FAO Rebecca Halliwell Application 3/2016/0685 Hollins Farm Rimington BB7 4EJ

Rimington and Middop Parish Council have no objection in principle to the proposed lambing shed .
However we would comment on two issues :-

Drawing Title
Proposed Plan, Section and
Elevations

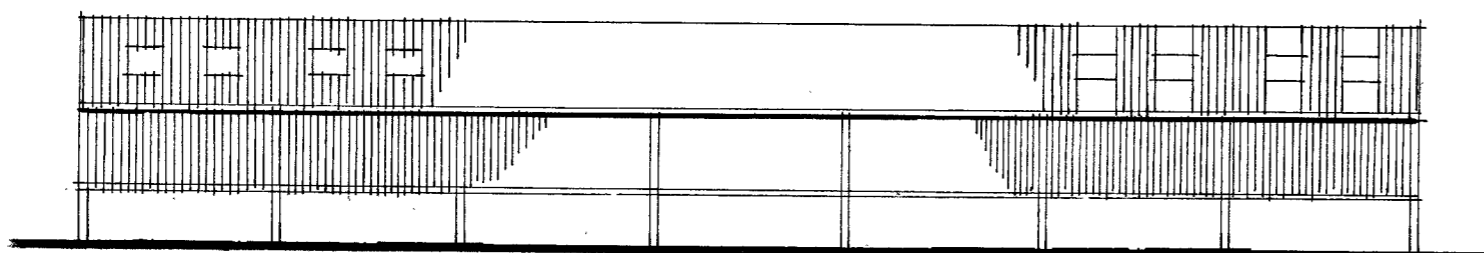
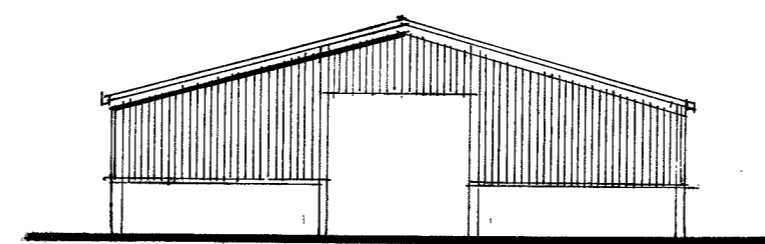
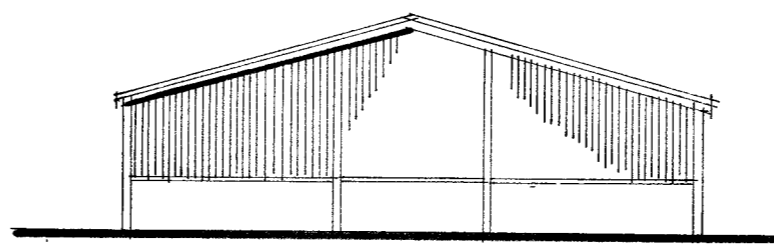
- 1) The online drawings were not clear and the proposed finish to the roof appears to read " Natural Grey ".
From existing buildings in the area natural grey can range from " Off White " through to " Storm
Cloud Black ".
A definitive colour should be stipulated in an effort to reduce to visual impact .
- 2) Comments have been made to the PC regards the delapidated buildings that appear to serve no
purpose
and are adjacent to the proposed site . Could there be negotiation or revision to improve the situation if a
new
building is to be permitted . It is understood that this topic has already been brought to your notice .
